Submissions and Amendment Report

SSD 37558583 – Lot 1 Bringelly Road Business Hub Warehouse Facility
Response to Submissions

01 LANDSCAPE SECTION AA  
SCALE 1:100 @ A1 / 1:200 @ A3

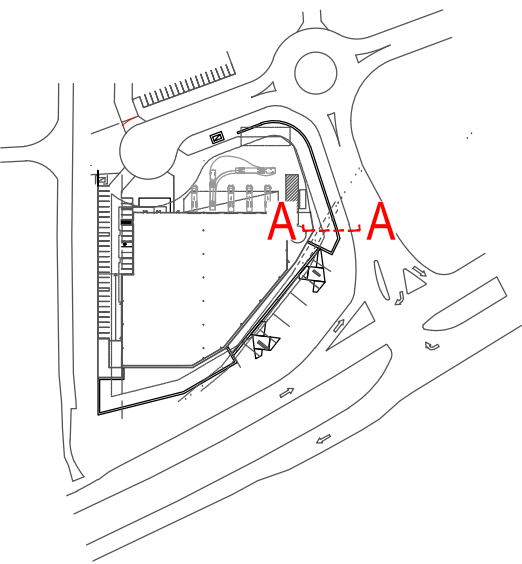
Consider additional offsets between the building and the retaining wall to provide access for maintenance and to safeguard the building. Provide detailed cross sections along Bringelly Road and Stuart Road (including the proposed building, retaining wall and landscaping) to illustrate the various interface treatments being proposed as part of the development.

The building design has been updated to include an additional 300mm offset between the retaining wall and building. This has been reviewed and deemed safe for maintenance by a fire engineer and BCA consultant. Long sections showing the 800mm gap have been prepared for the proposed development and can be viewed at **Appendix A**.

RETAINING WALL PLAN

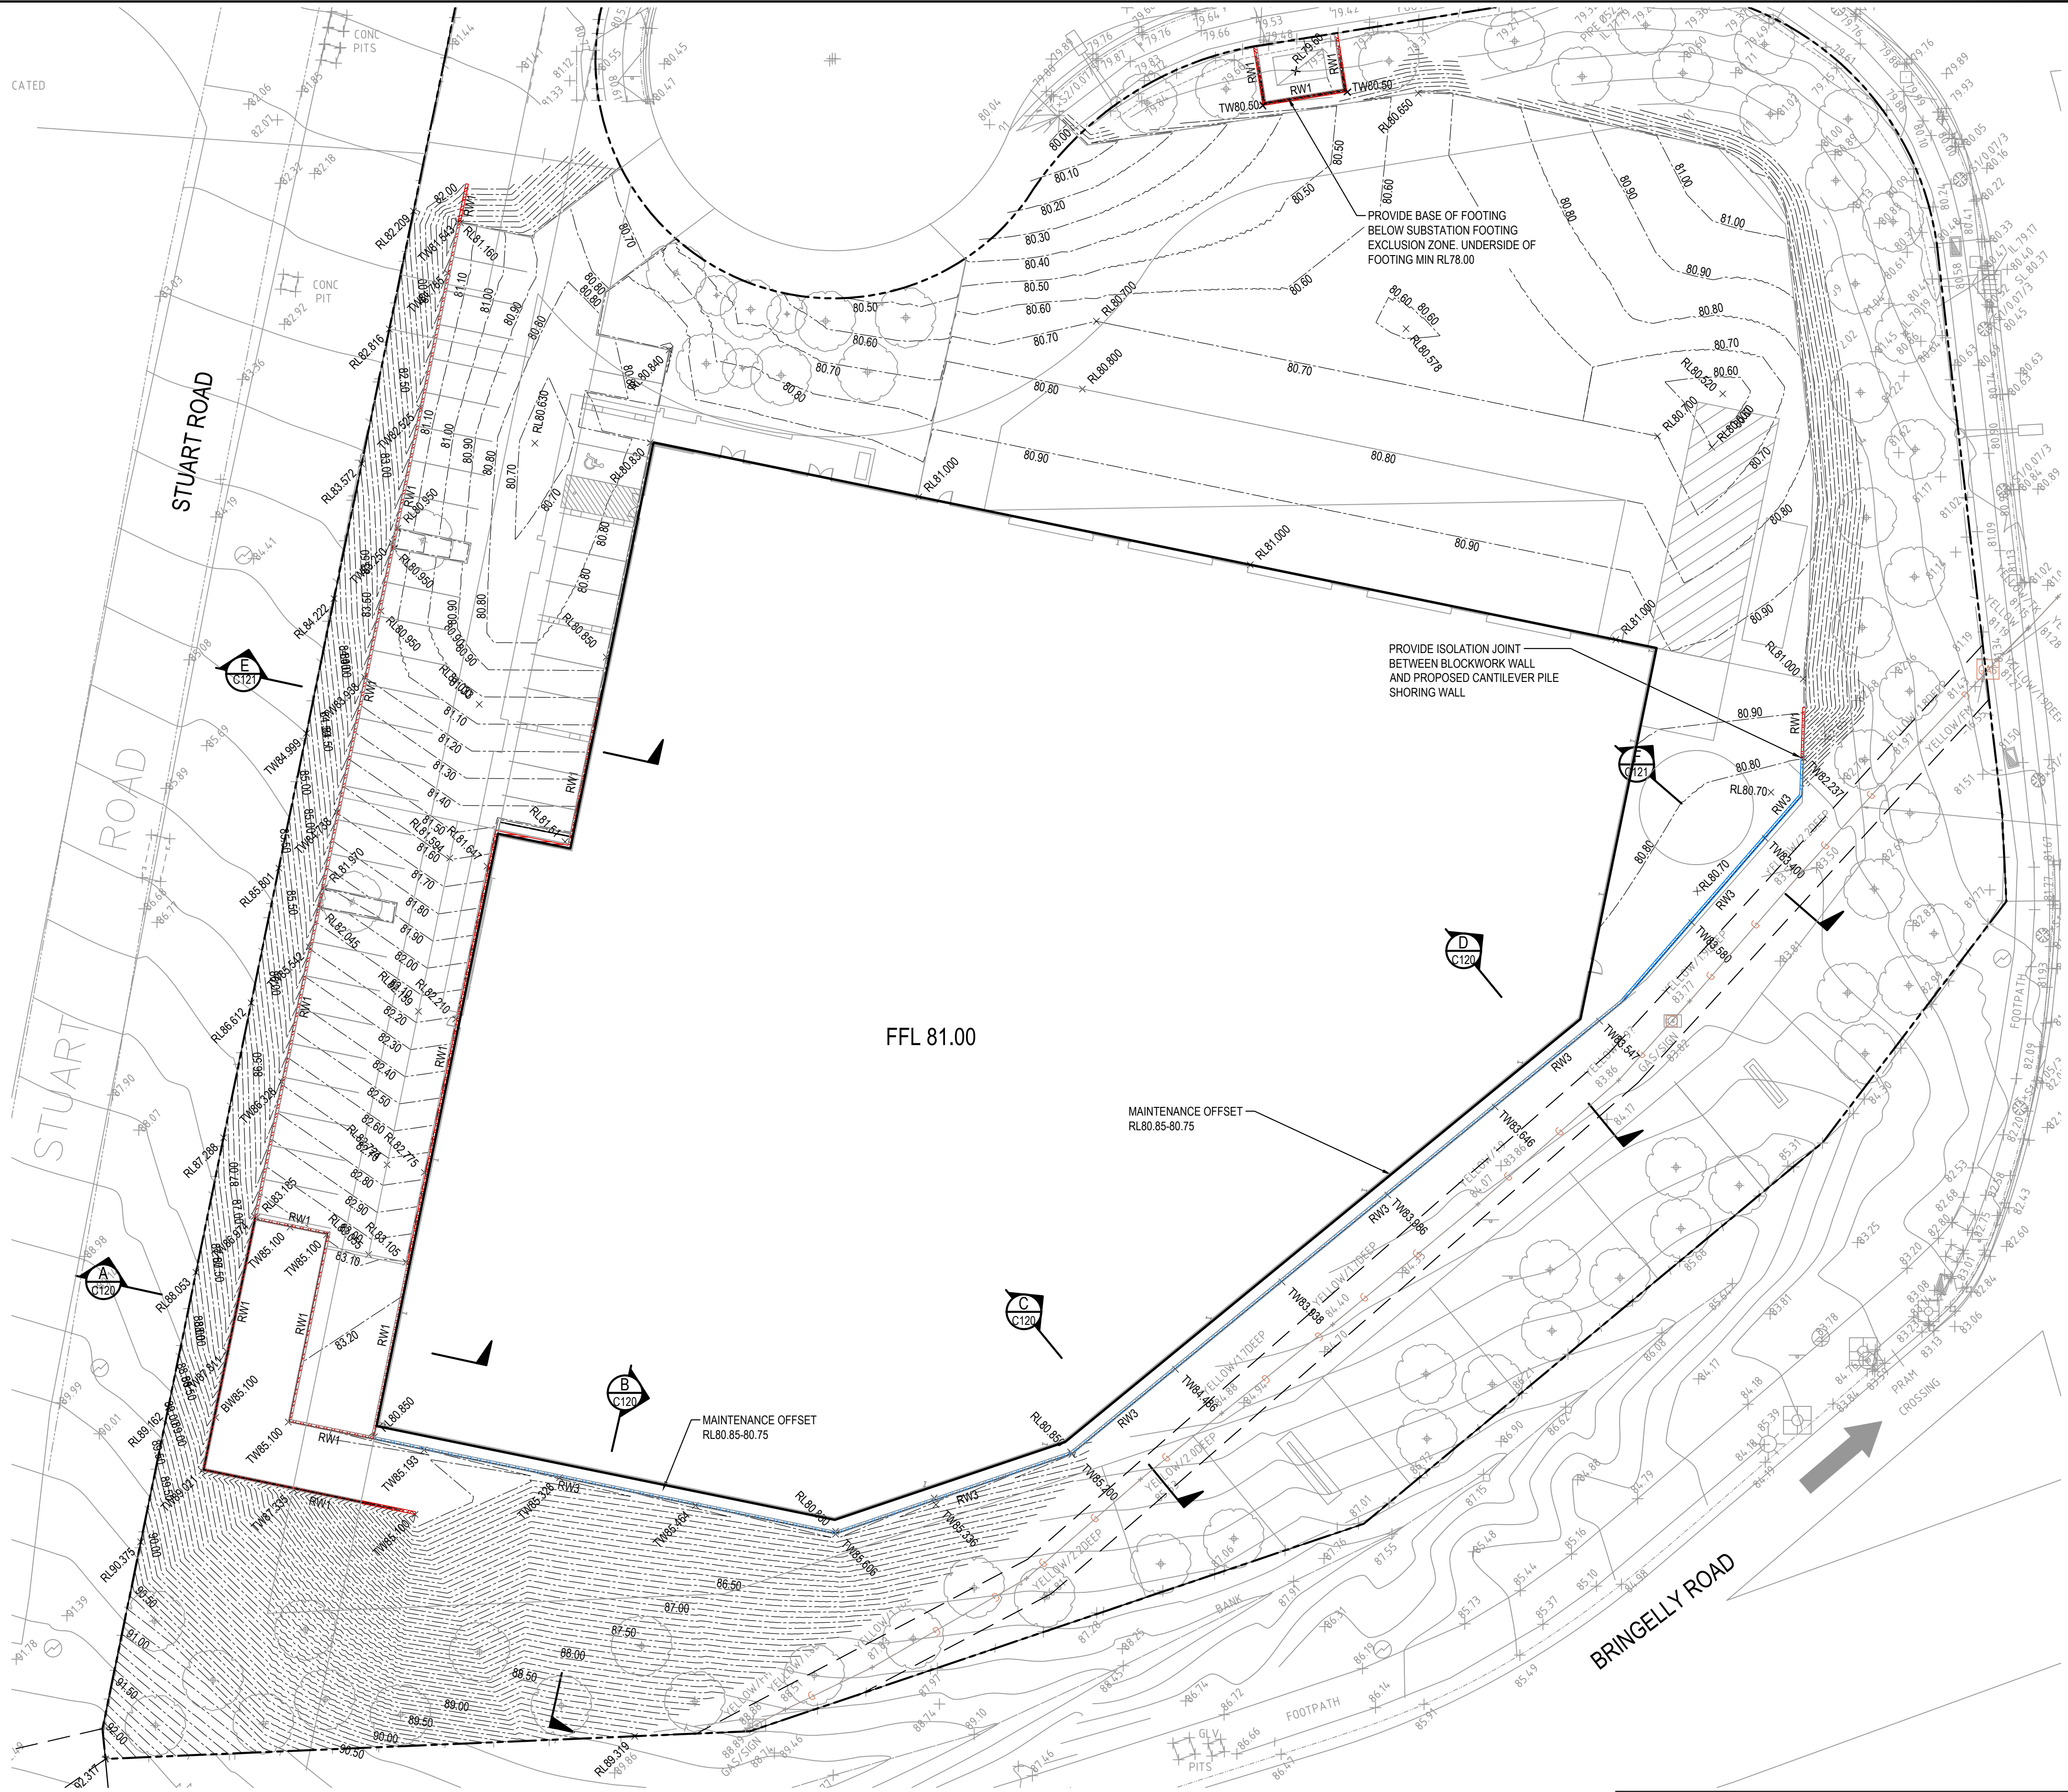
Comment	Response
It is acknowledged that significant retaining walls are proposed as part of the development. The engineering plans showing these may reach more than 3 m in height. The Department is concerned that retaining walls of this height may cause visual impacts. Further details are required to determine how these walls will impact on the visual amenity of the site, including the inclusion of these walls on elevation plans, multiple section plans and montages to demonstrate the visual impact of these retaining walls from within the subject site and from neighbouring sites.	The cut and fill strategy creates a lower pad compared to levels of Bringelly Road and Skyline Crescent. This reduces the scale of the warehouse perceived from these roads, thus minimising its impacts across the broader landscape. Therefore, the retaining walls will not be visually dominant in the surrounding areas. Refer to Appendix B for section plans/montages demonstrating the visual impact of the retaining walls. The Engineering Plans at Appendix E have been updated to reflect the amended design of the built form.
